Planning Application Review

LLFA Assessment

Planning authority: Redcar and Cleveland Borough Council
Associated name: DCO Scoping Lighthouse Green Fuels Project
Date received: 24/11/2025
Date response submitted: 13/01/2026

Scoping Opinion for DCO Scoping Lighthouse Green Fuels Project.

Figure 10.5
Watercourses and Waterbodies within
250m of the Proposed Development

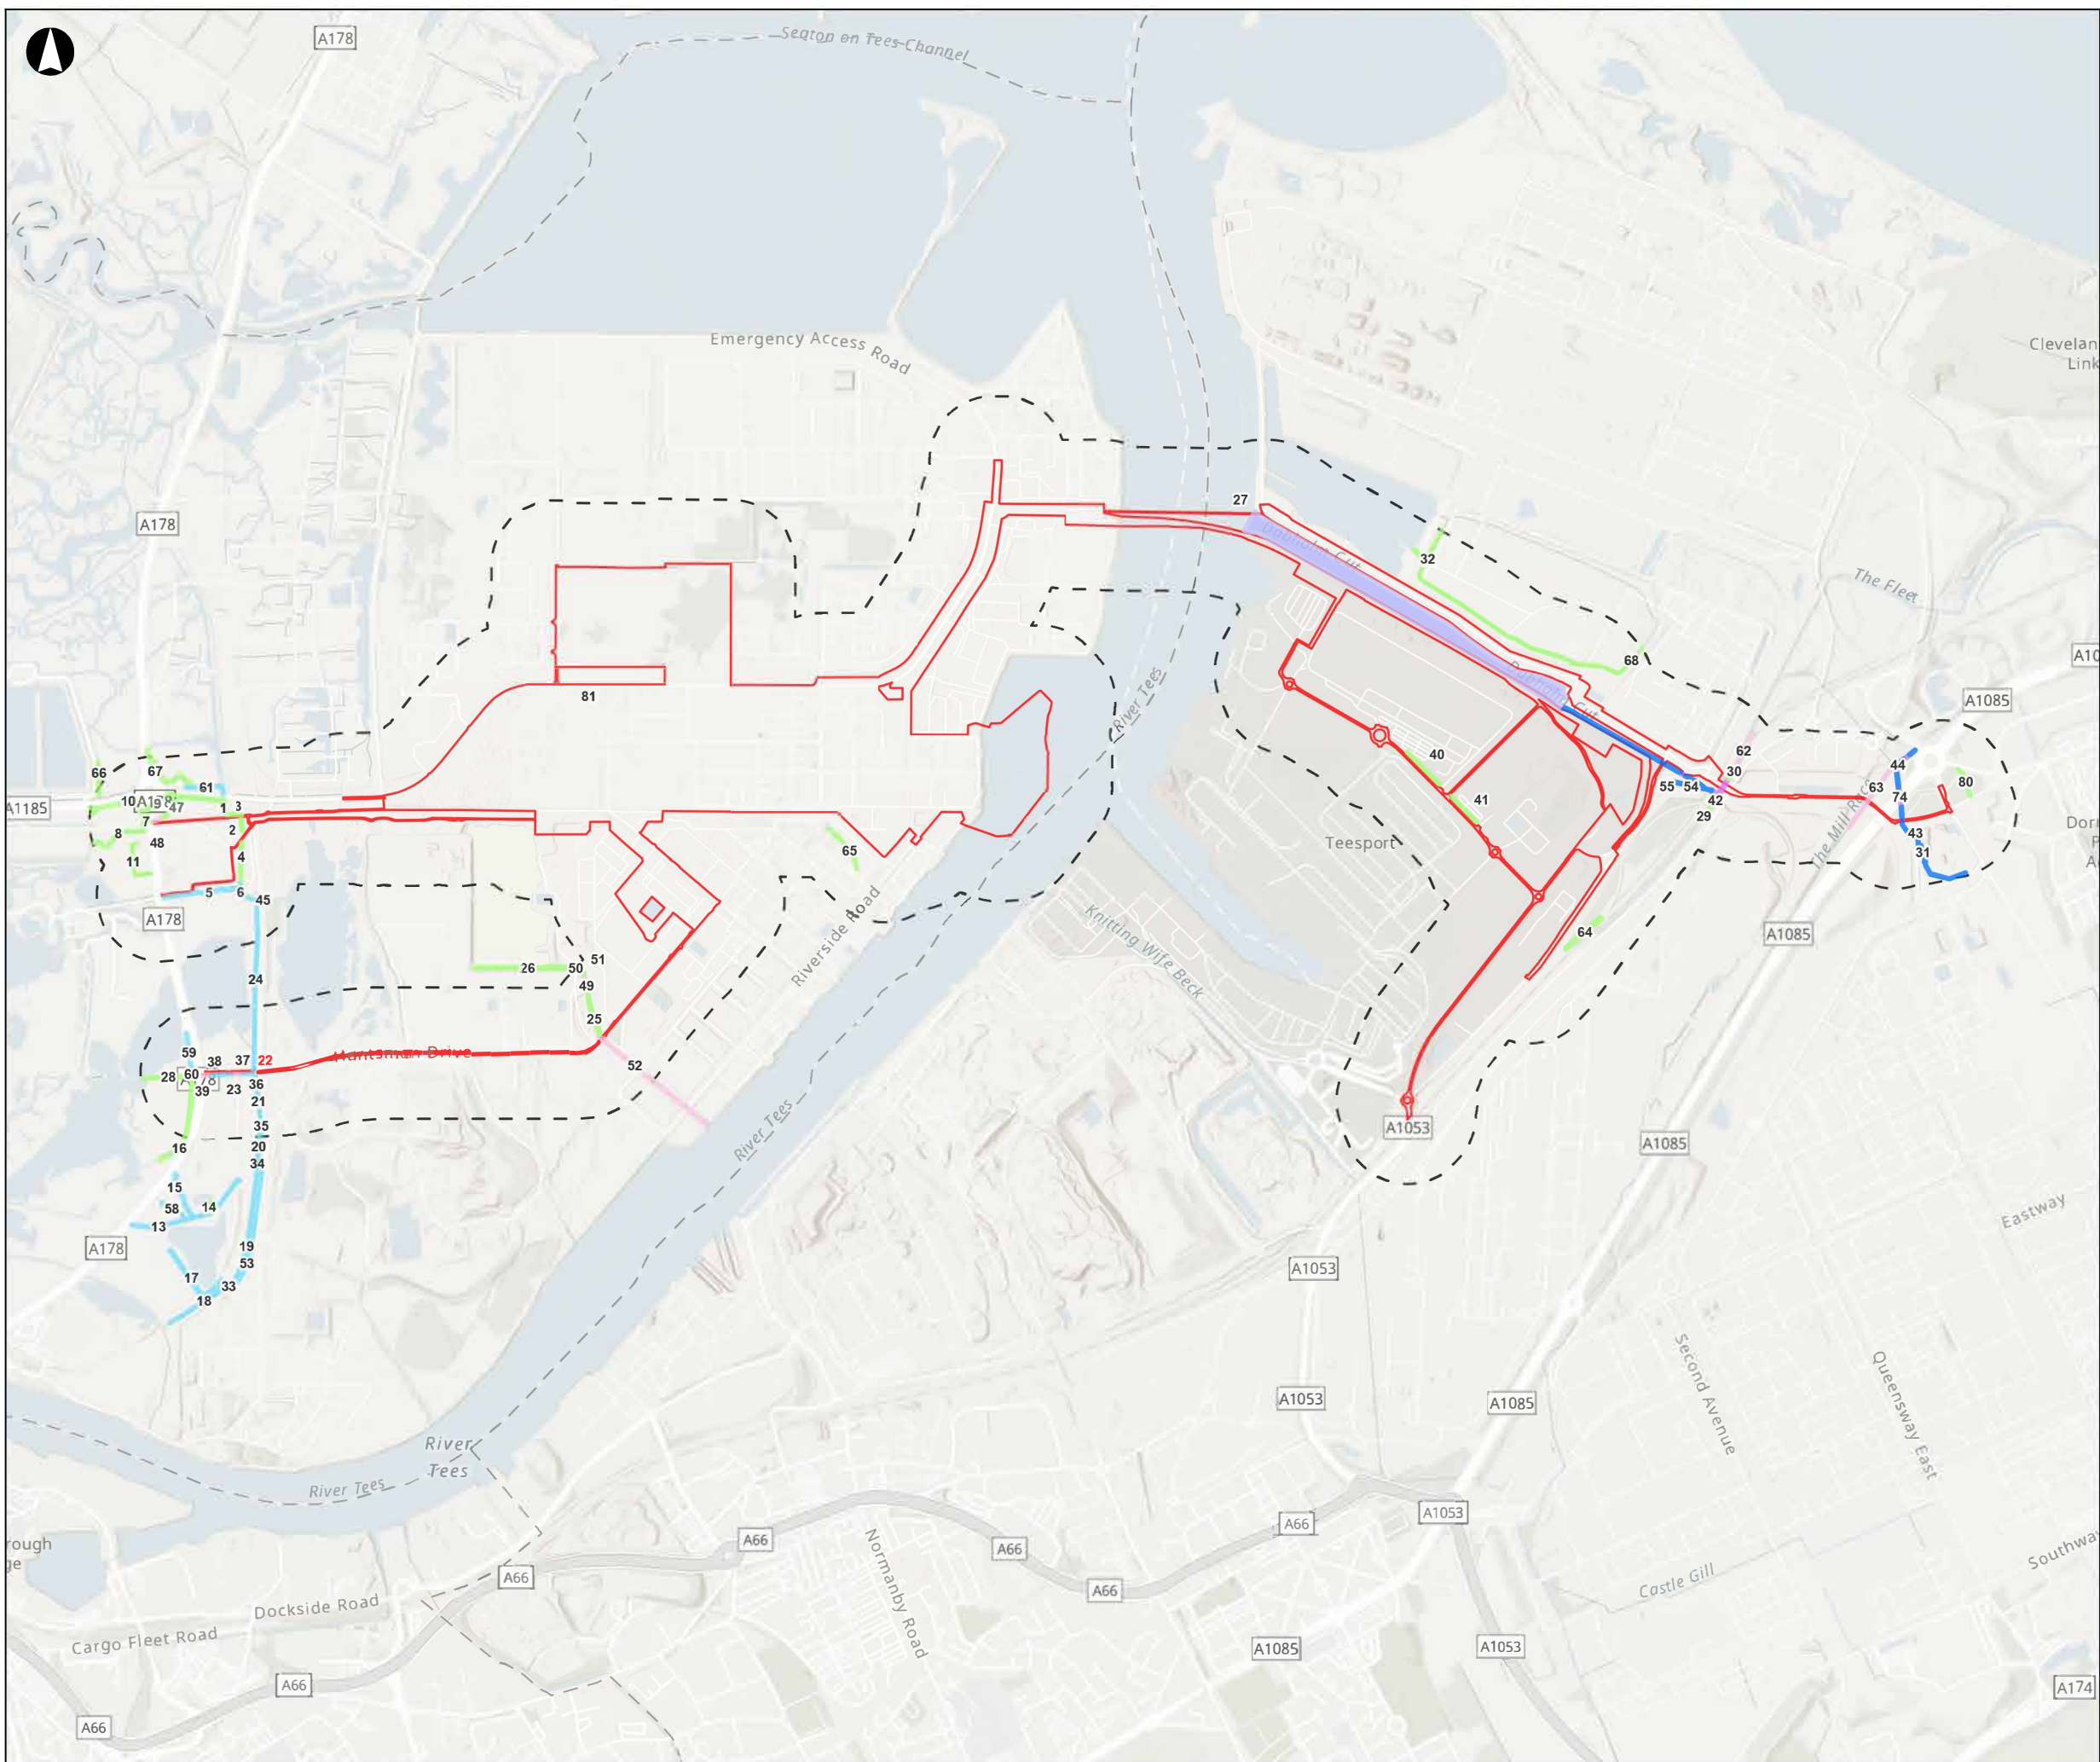
Works are proposed adjacent to Dabholm Gut watercourse. Ordinary Watercourse Consent may be required at subsequent stages. Proposals, including any access crossings, should consider easements and be designed to ensure the current flow and capacity of the watercourses are not impacted.

Risk of Flooding - Surface Water

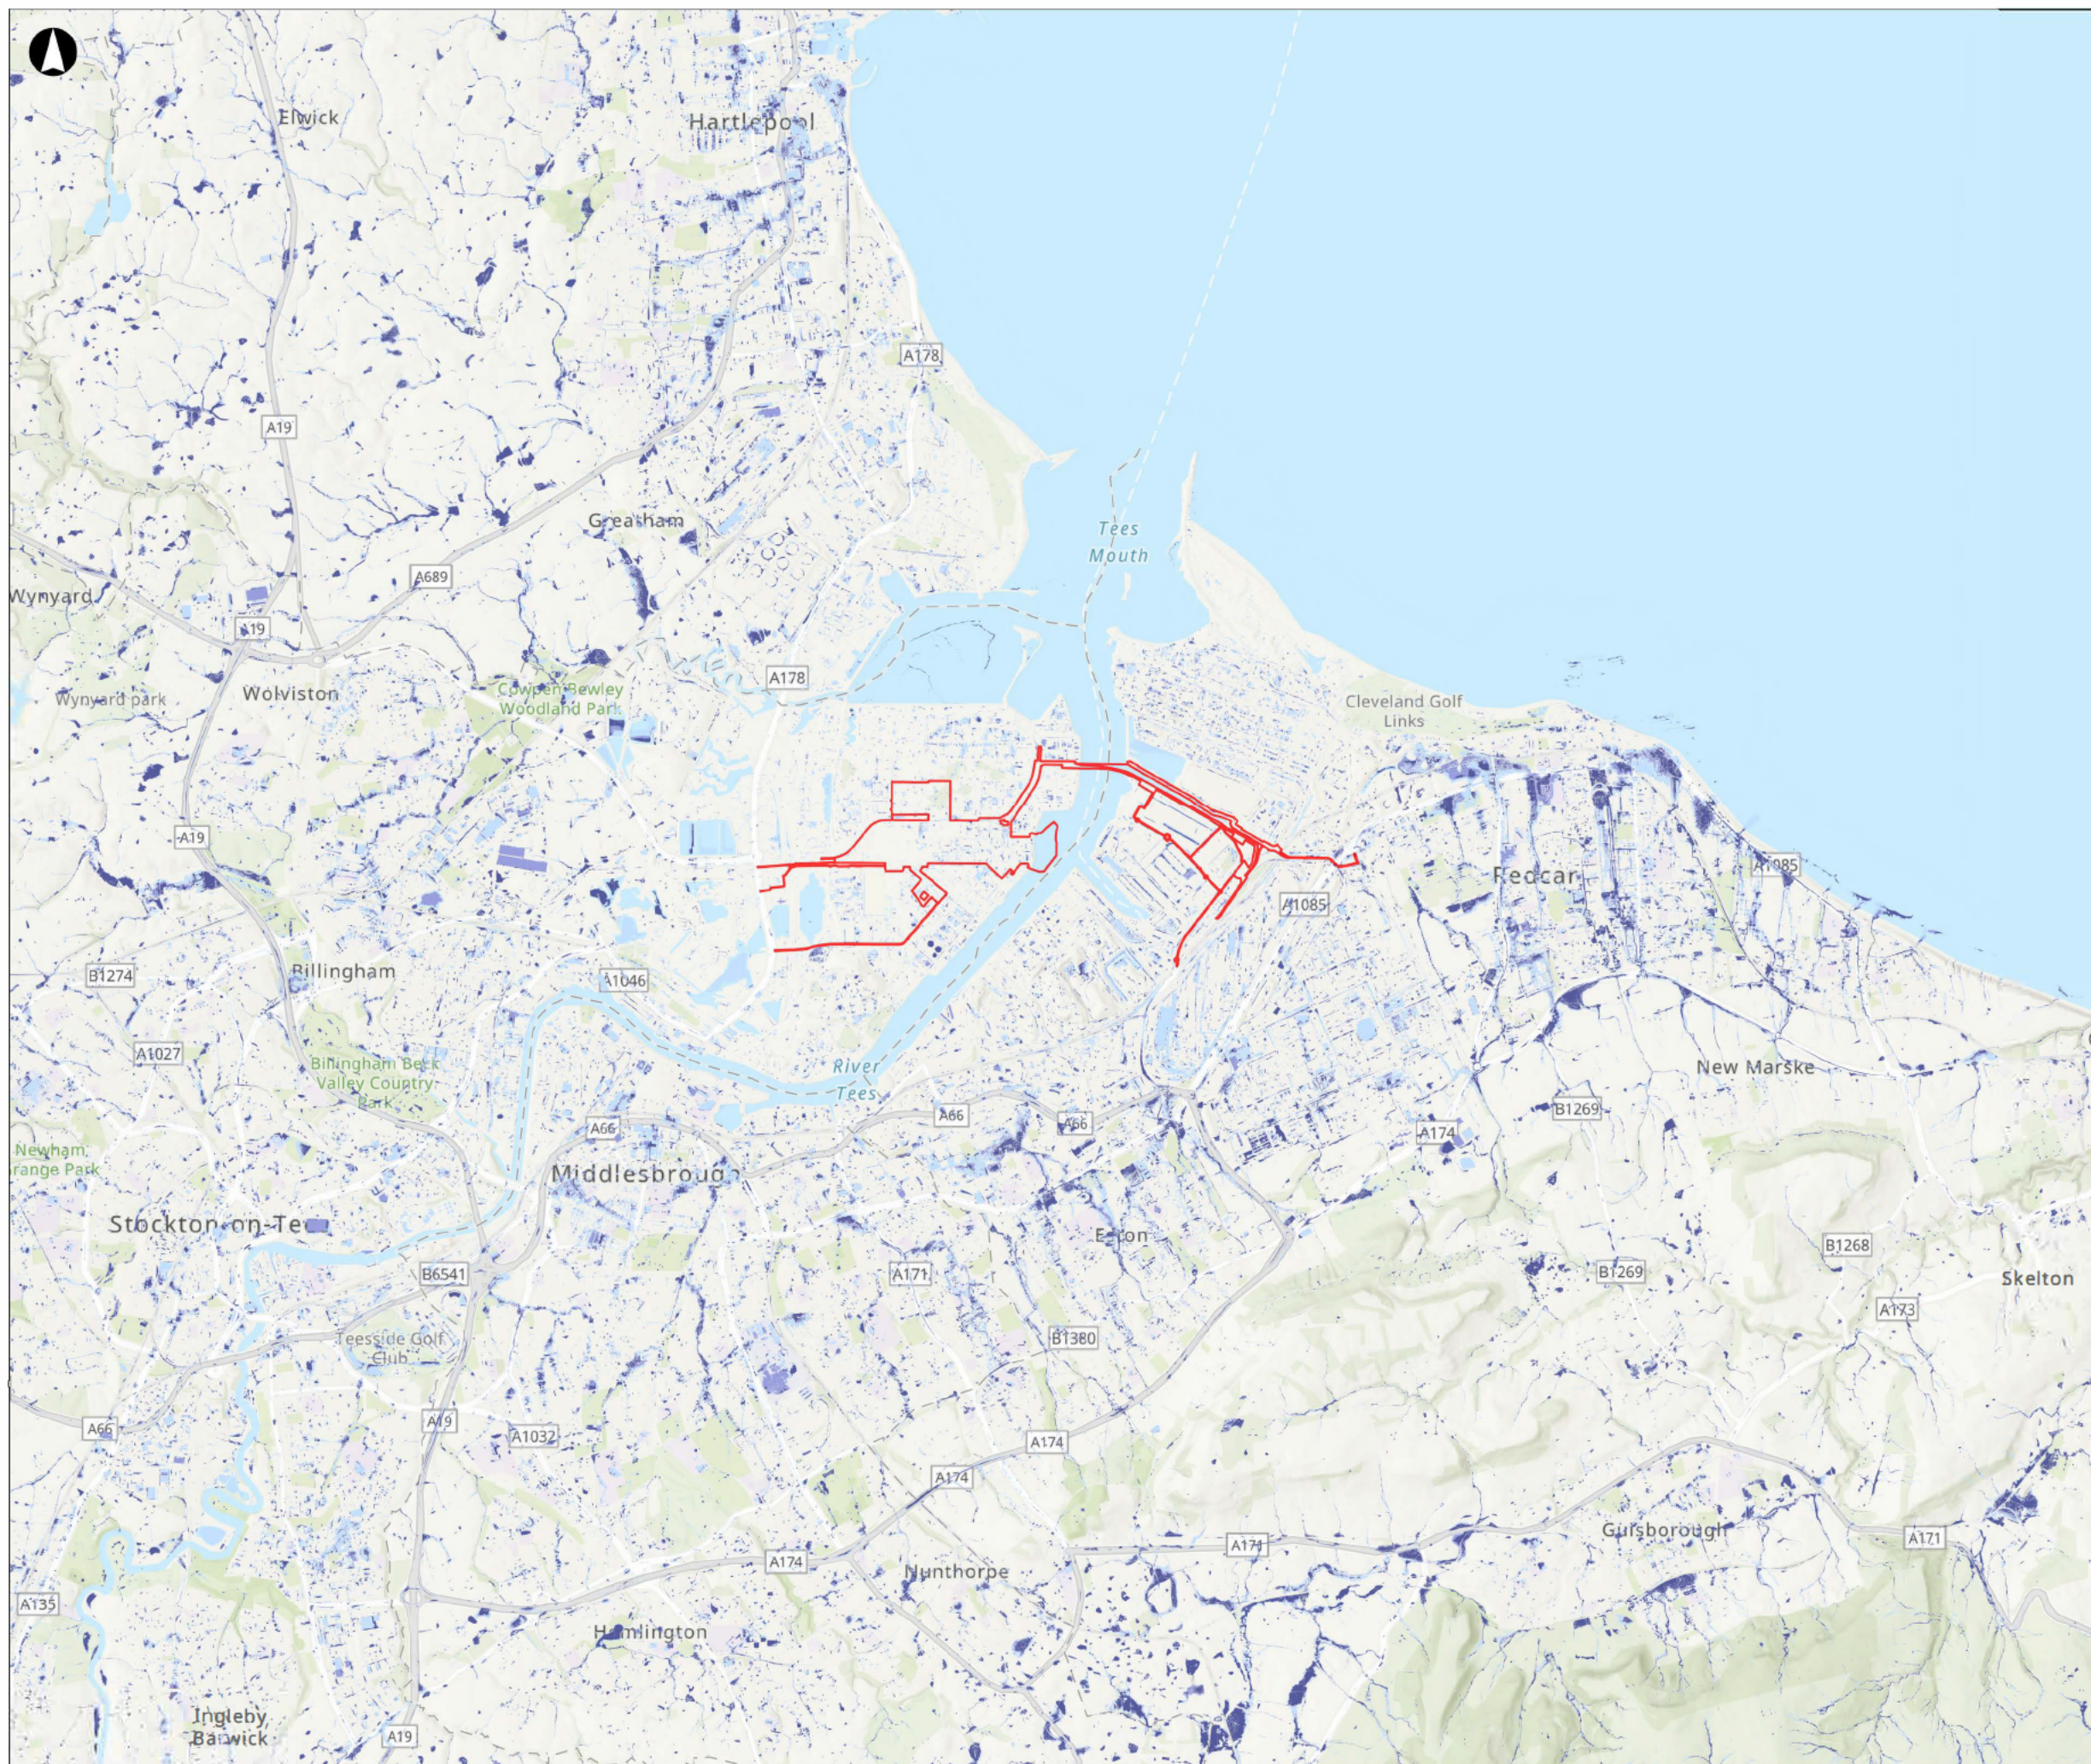
It appears that proposals within the Redcar and Cleveland Borough Council area are mostly utility corridors. These areas are projected to lie within Flood Risk Zone 2/3 under the 2070 to 2125 climate change scenario provided by EA's online flood maps¹. Development within flood zones must not increase flood risk elsewhere.
